Map 6 SR1363 S. Mebane St.  
 Existing asphalt in gutter throughout Map.  
 Mill and Repave in Gutter.

Map 7 SR 1515 Flora Ave.  
 Skip intersection at SR 1529 Durham St.  
 Tie down resurfacing to the end of curb and gutter on NC 87.

DEEP-CUT INDUCTIVE DETECTION LOOPS
 (FOR INSTALLATION PRIOR TO MILLING)

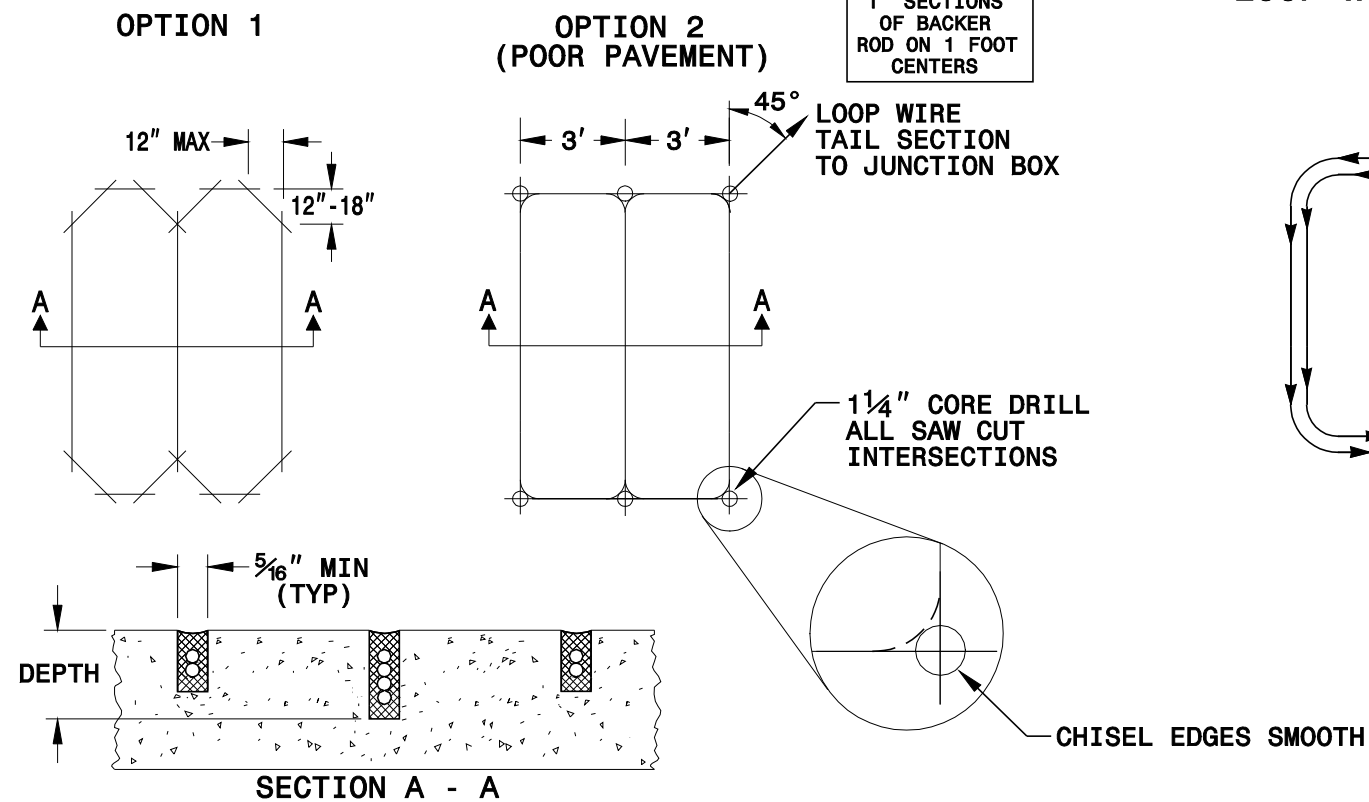
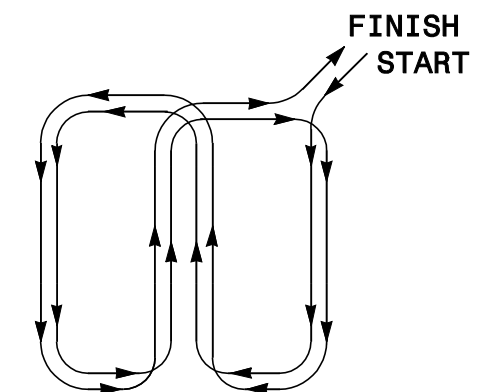
\* Signals in Burlington and Graham, please change the existing 6x50 & 6x60 quadrapole to 6x40 quadrapole loops. Any loops crossing lanes ie 6x15, 6x20, 6x30 keep as per plan, Redline all changes of loops on cabinet plans and notify City of Burlington of Changes. City of Burlington will adjust times and mark up plans as needed.
